Proposed Solar Farm and Bess Facility, Bardling's Drove, Sutton St. James, Spalding

Highways Technical Note

Response to Highways Comments from Lincolnshire County Council

21st February 2025

Project:			FEN DYKE SOLAR FARM		
Client:			INTEGRUM RENEWABLE ENERGY LTD		
Drawing:			PROPOSED ACCESS ARRANGEMENTS - SITE 1		
Drawn By:		Date:			
MSF		25.06.2024			
Checked:		Scale:		Paper:	
SD		1:1000		A3	
Drawing No.			Rev.		
AMA-22709-SK-001			P05

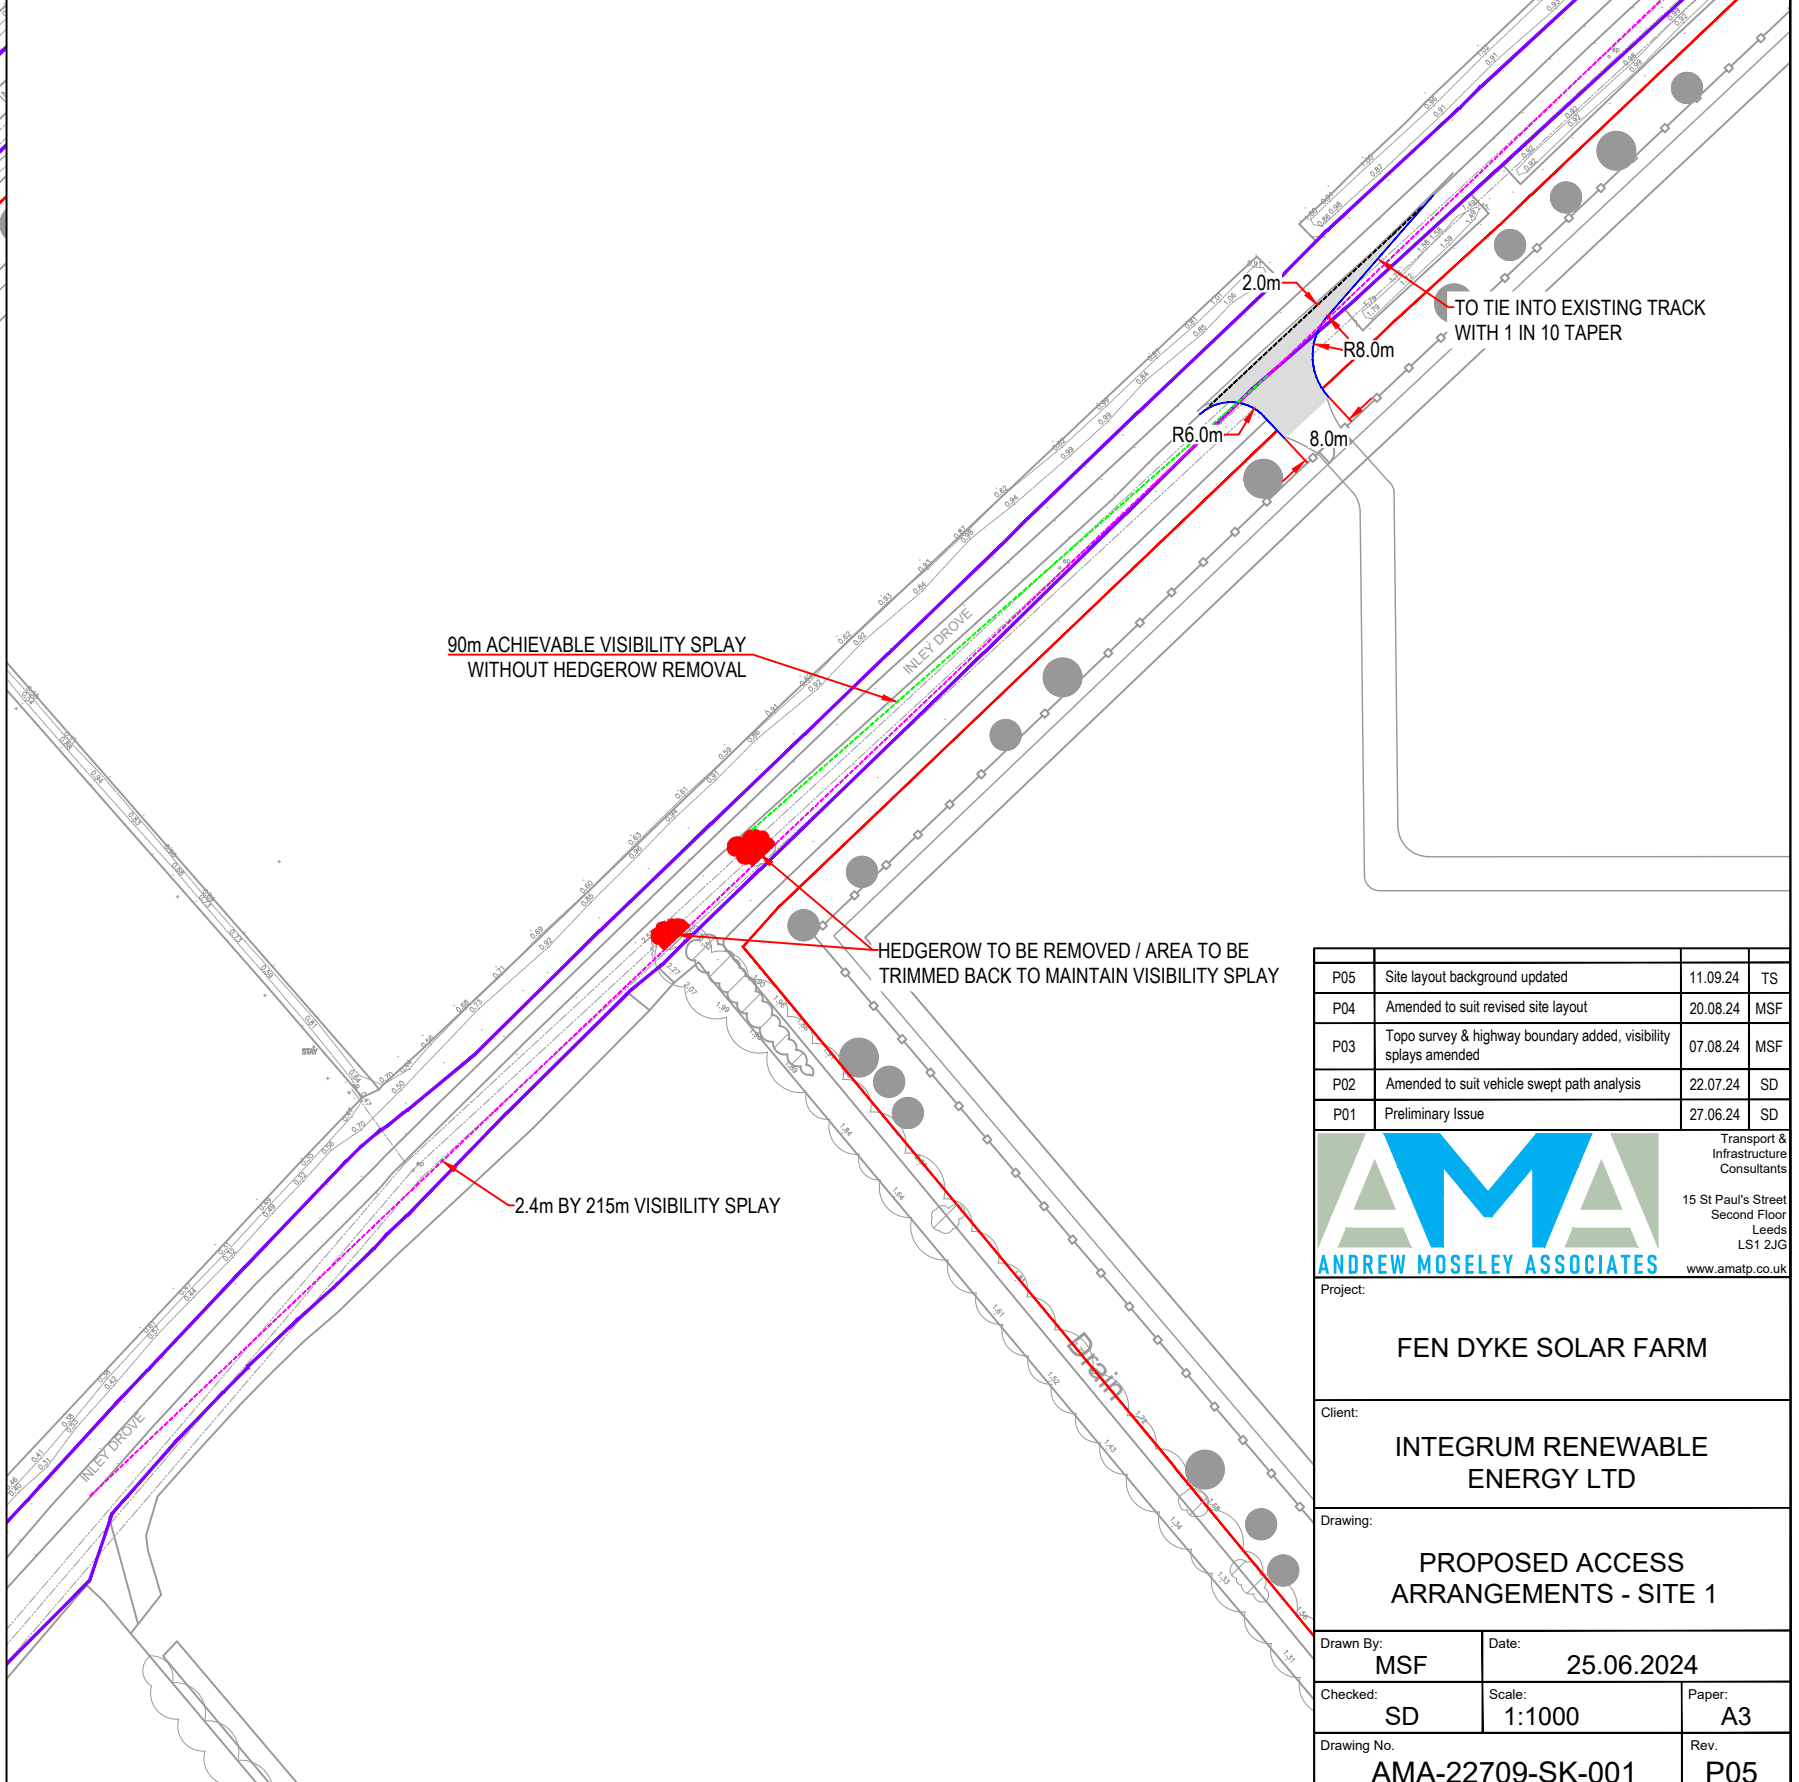
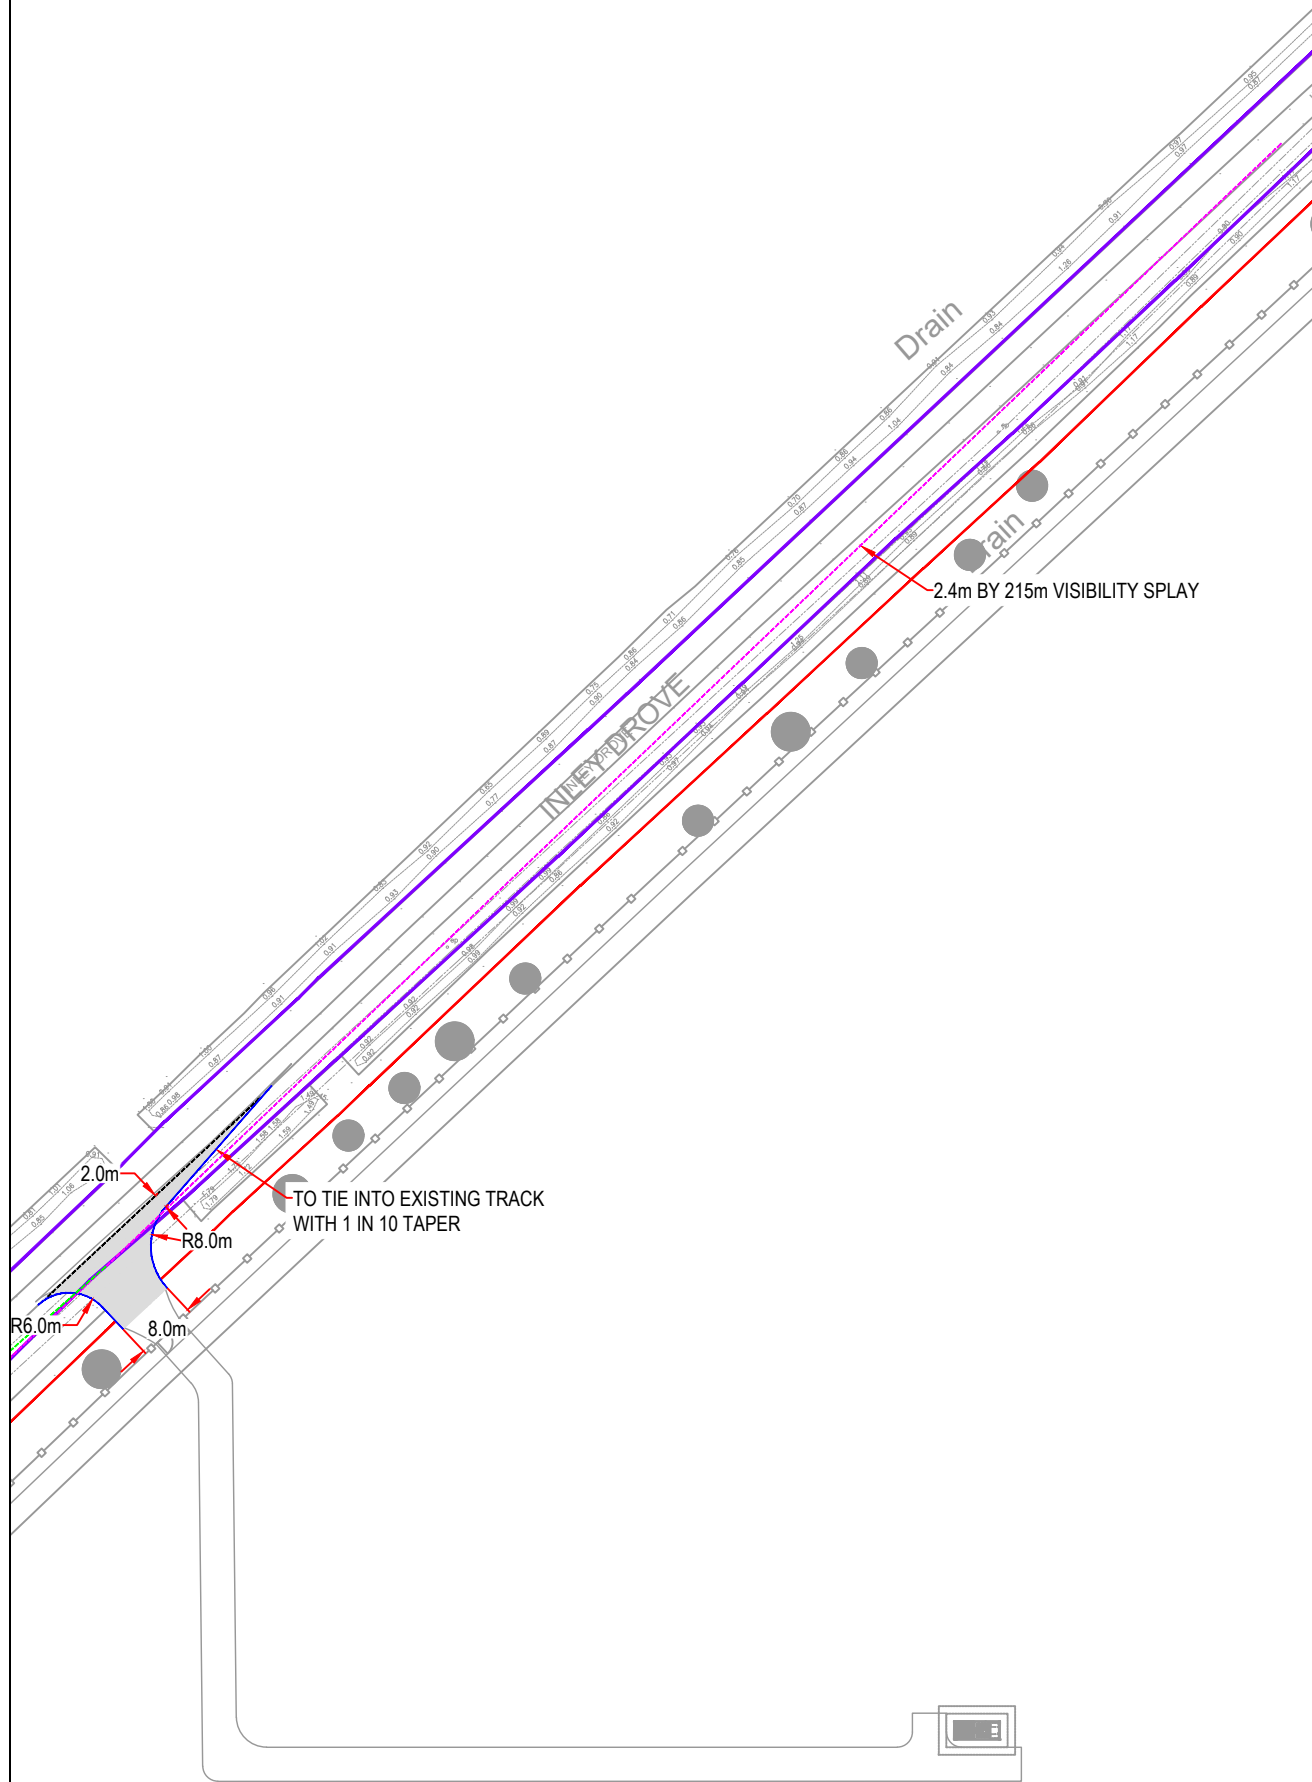
Visibility has been demonstrated in accordance with DMRB this is not necessary – they should be measured in accordance with Manual for Streets.

Detailed access drawings are required with swept path drawings detailing the largest size vehicle that will be accessing the sites.

Whilst this response is open ended, AMA have taken into account LCC's views regarding the rural and lightly trafficked nature of these roads and therefore consider the provision of visibility splays in line with Manual for Streets (MfS) for a 30mph road appropriate. All visibility splays have been updated as requested and these can be viewed at [Appendix C](#).

AMA can confirm all construction accesses will be constructed in accordance with LCC specification, and AMA's preliminary drawings have been updated to reflect this. Please see [Appendix C](#).
